From: Kate Giddings <kate.giddings@arun.gov.uk>
Sent: 09 July 2020 16:32
To: Amy Myer <Amy.Myer@arun.gov.uk>
Cc: Planning.Responses <Planning.Responses@arun.gov.uk>; Chantelle Bashford <Chantelle.Bashford@arun.gov.uk>
Subject: LU/163/20/PL - 6 Selbourne Place, Littlehampton, BN17 5NH

In relation to the above application, please may EH comment with the following suggested conditions:

Proposed Second Floor Plan 1:50

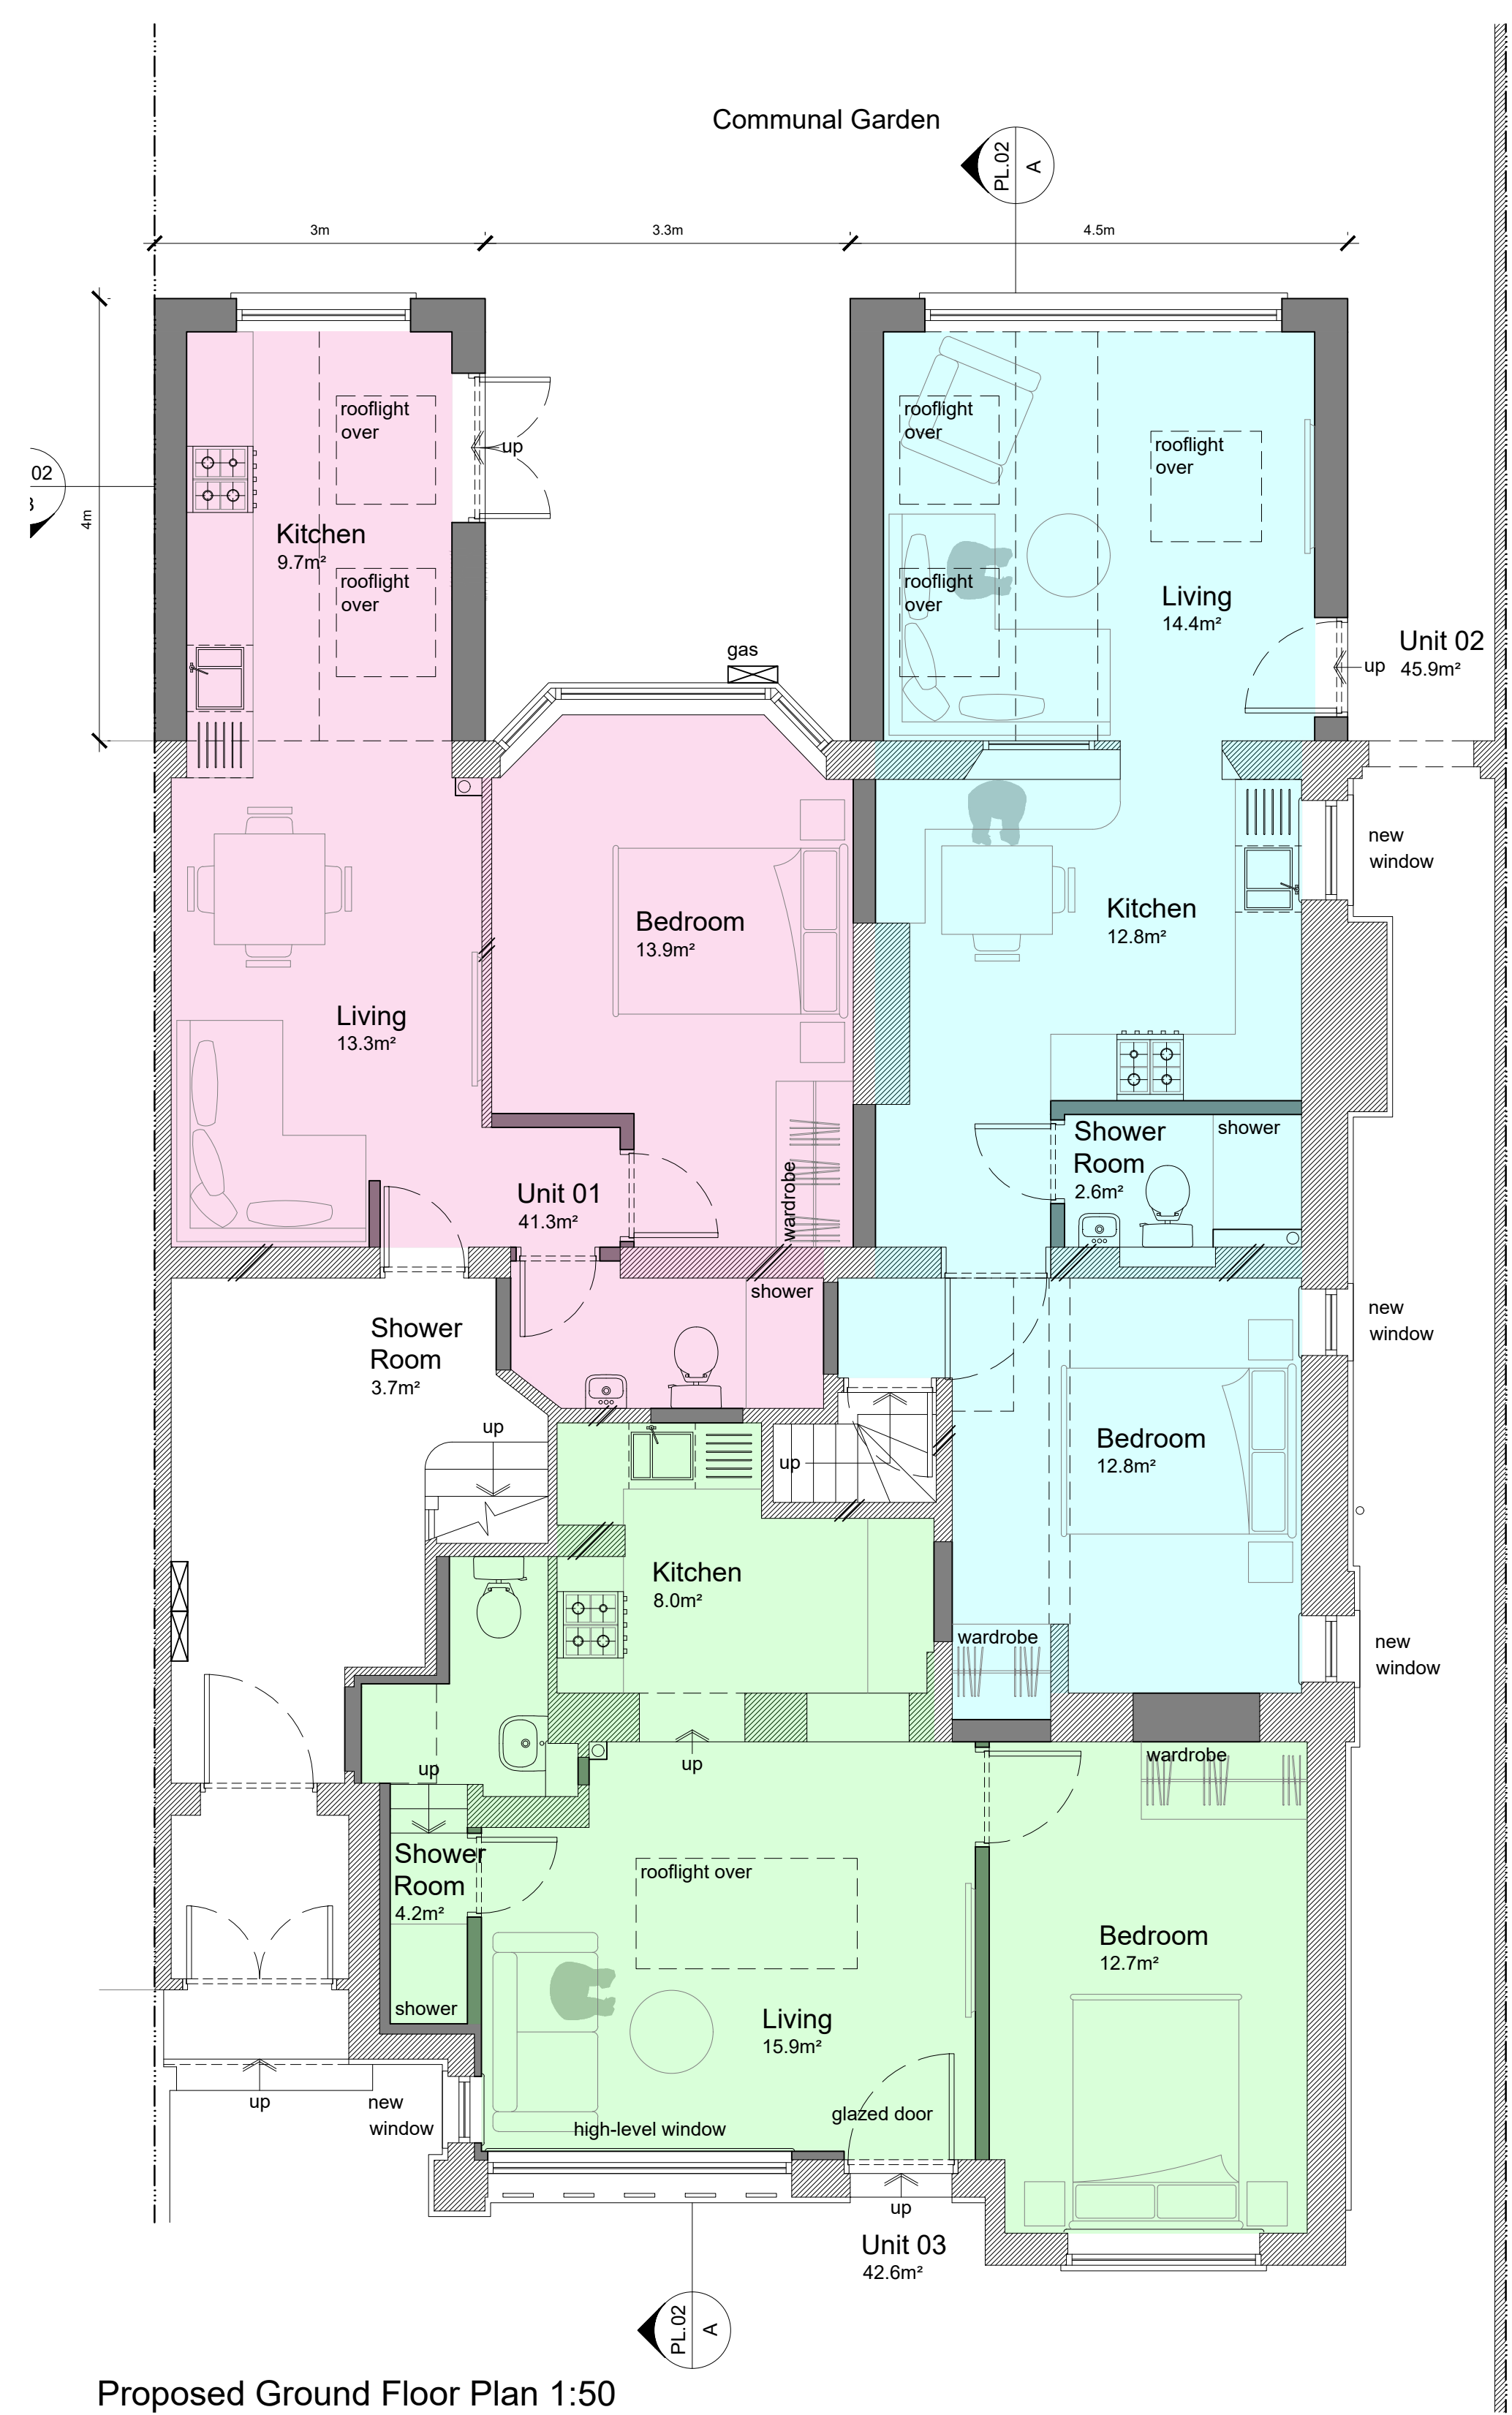
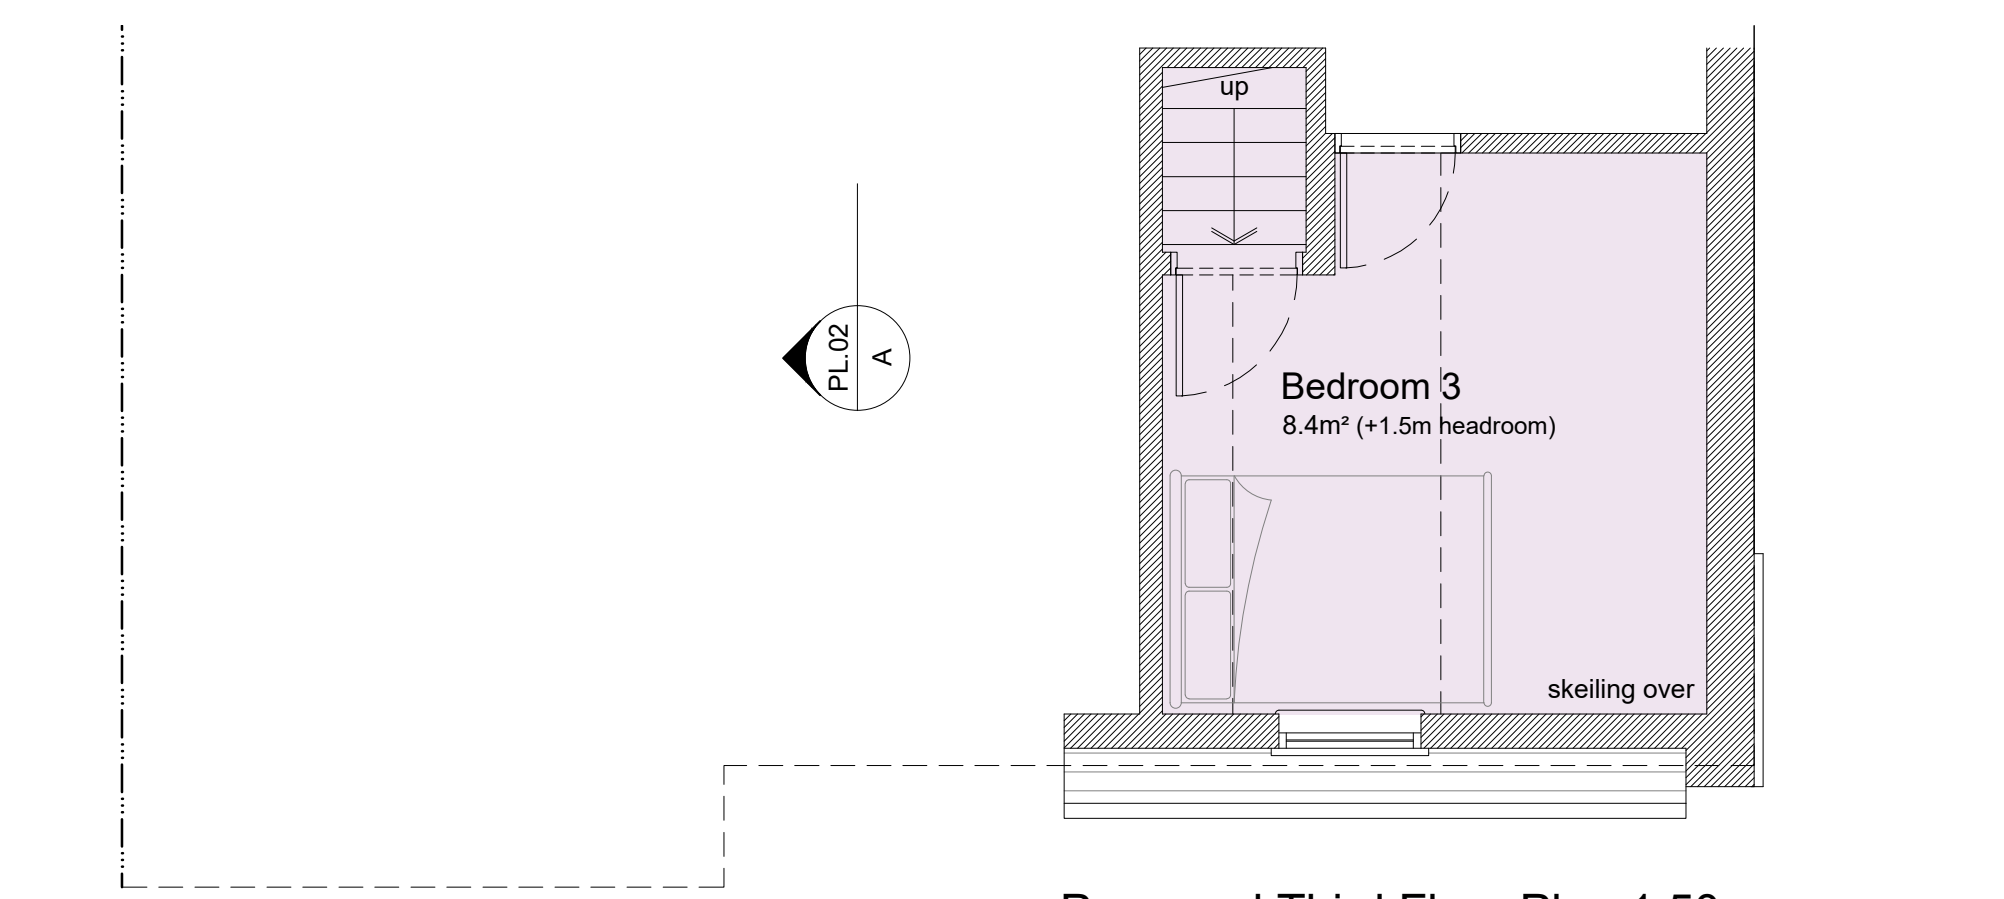
With regard to the proposed internal layout of the building, there are concerns regarding noise propagation between the units, specifically between:

1. the bedroom of Unit One and the overlying kitchen/living space of Unit 4;
2. the kitchen of Unit Two and the overlying bedroom with *en suite* of Unit 4.

It is therefore recommended that the following condition be applied:

- Prior to the commencement of the development hereby approved, a scheme to demonstrate that the internal noise levels within the residential units will conform to the 'Indoor ambient noise levels for dwellings' guideline values specified within Table 4 under section 7.7.2 of BS 8233:2014 and shall be complied by a competent acoustician on sound insulation and noise reduction for buildings and shall be submitted to and approved in writing by the Local Planning Authority. The scheme should take into account the correct number of air changes required for noise affected rooms. The works specified in the approved scheme shall then be carried out in accordance with the approved details prior to occupation of the premises and be retained thereafter. **Reason:** To protect the amenity of local residents in accordance with Policy QE DM1 of the Adopted Arun Local Plan 2011 – 2031.
